Planning Application No: 3/2025/0377

Proposal: Prior approval for the proposed change of use of a former agricultural building to one dwellinghouse under Schedule 2, Part 3 Class Q of the GPDO.

Location: Fields Farm, Mearley, Pendleton BB7 1PU

<b>project</b> fields farm	<b>project number</b> 25.07	<b>drawing number</b> <b>PL.01</b>
<b>name</b> proposed - site plan		
<b>scale</b> 1 to 100 @ A1	<b>date</b> may 2025	<b>status</b> planning
		<b>revision</b> A

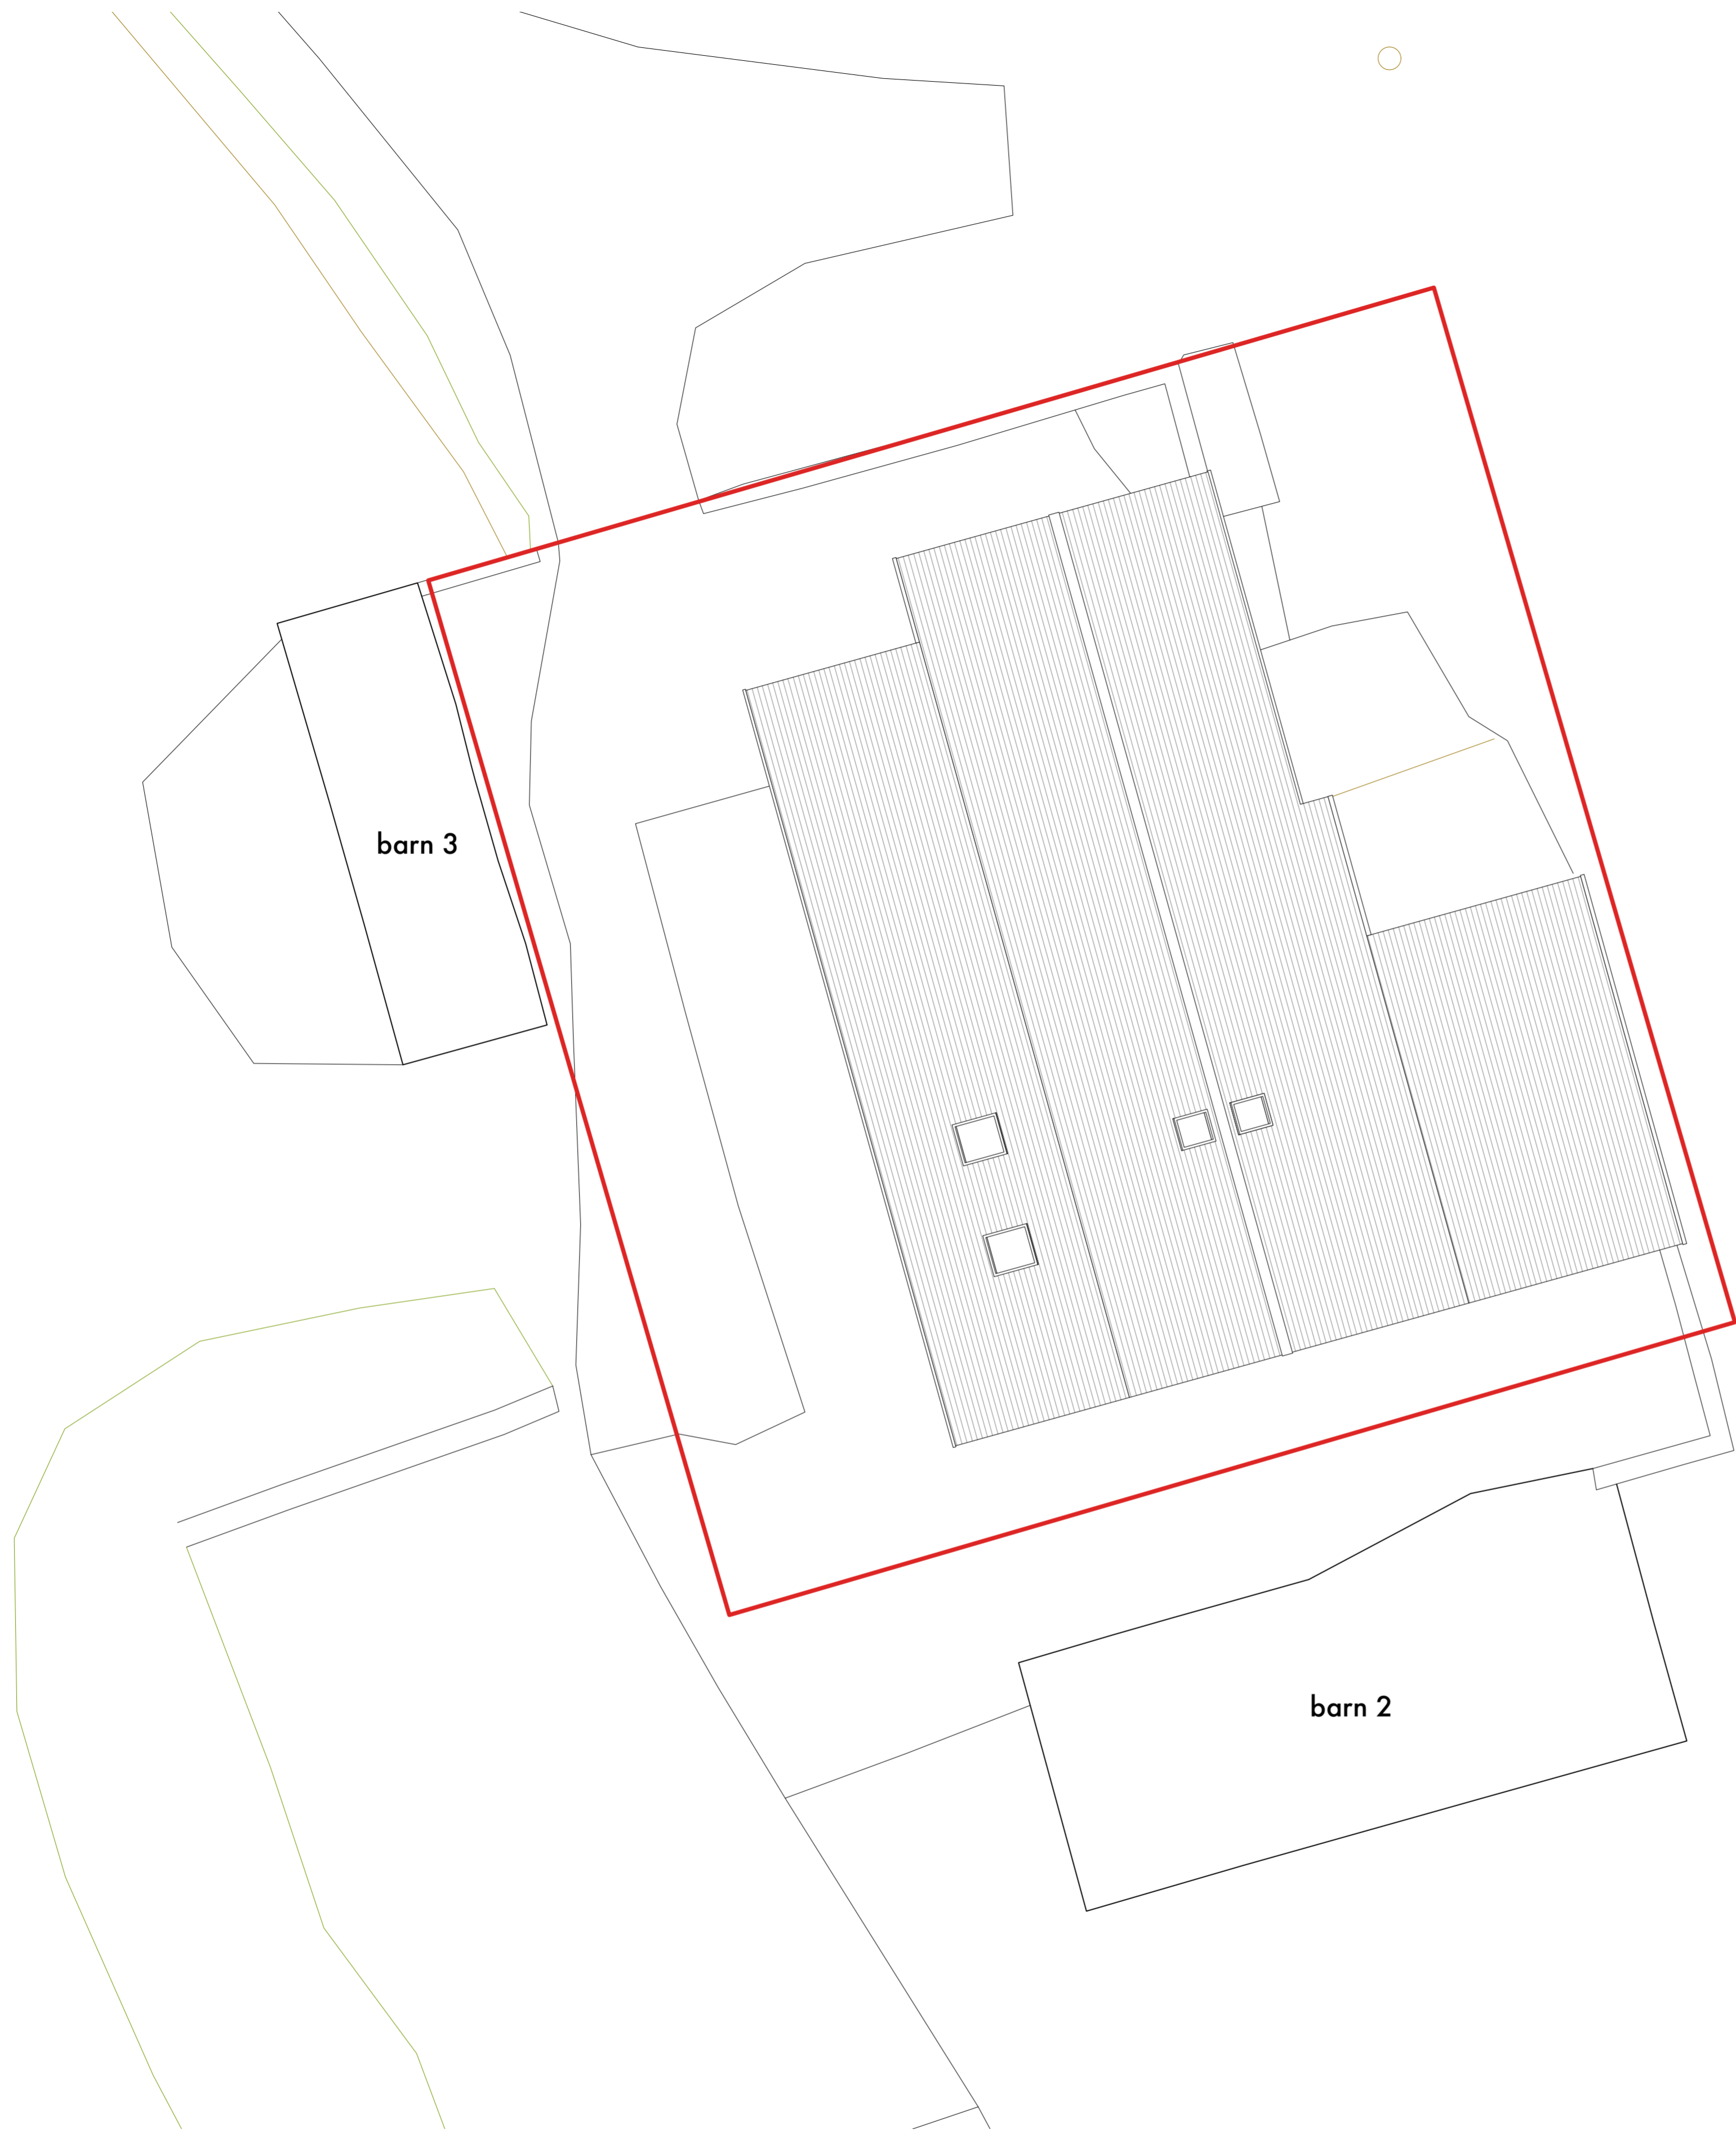
No car parking has been indicated on the submitted drawings. However, as the applicant owns the land surrounding the development site the highway authority considers that car parking can be provided. The highway authority would expect three car parking spaces, an electric vehicle charging point and a secure covered cycle store to be provided for the 5 bedroom dwelling. No vehicles should obstruct the line of the footpath recorded on the Definitive Map of Public Rights of Way.

project	fields farm	project number	25.07
name	location plan	status	planning
scale	1:1250 @ A1	date	may 2025
revision	B	drawing number	ex.00

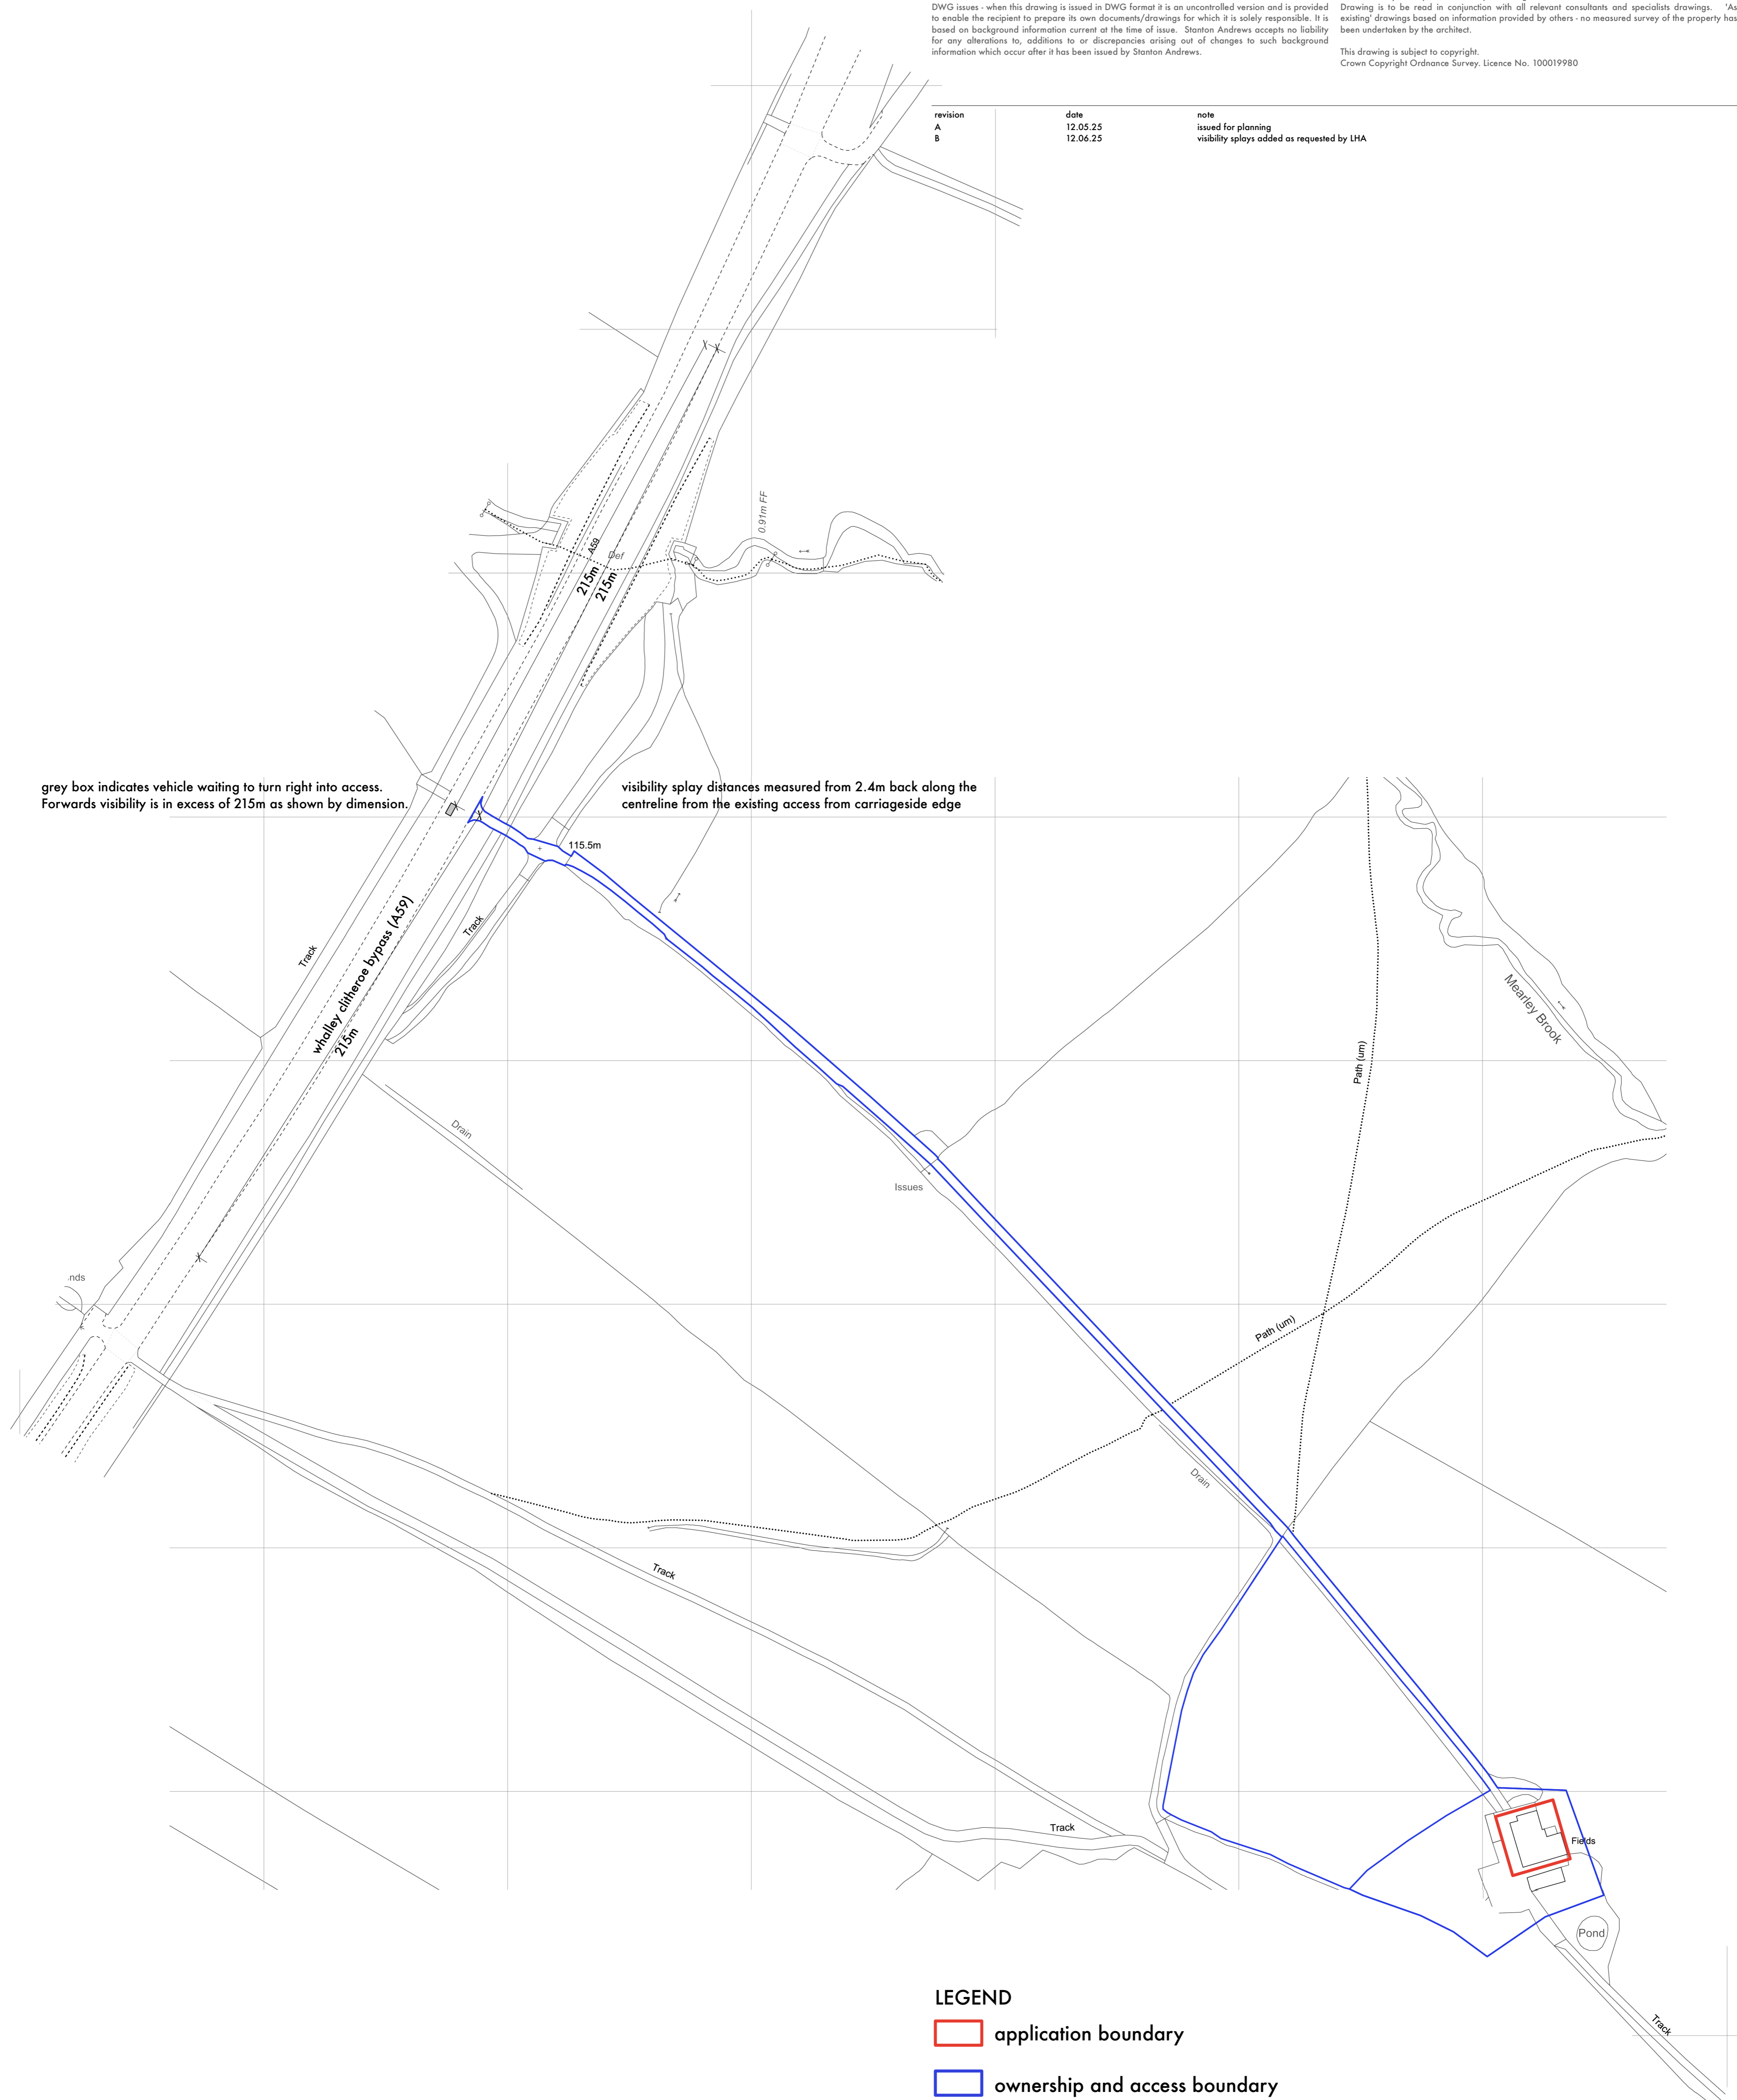
The A59 is subject to a national speed limit of 60mph for which a Stopping Sight Distance (visibility splays) of 215m should be provided in both directions measured 2.4m back from the carriageway edge along the centre line of the access.

Given the carriageway lanes layout and road geometry of the A59 the highway authority requested that an additional drawing was submitted to demonstrate the splays at the existing access.

A revised Location Plan (Drawing ex.00 reb B dated 12.6.25) was submitted to the local planning authority. This demonstrates that visibility of at least 215m can be achieved from both locations.

We have reviewed this additional information and conclude that although visibility splays can be achieved for the speed limit, that the introduction of a direct residential access on the A59 would be detrimental to highway safety for both the residents, their service requirements (emergency, refuse, deliveries, postal service) and highway users travelling along the A59. This is due to the high volume and speed of traffic.
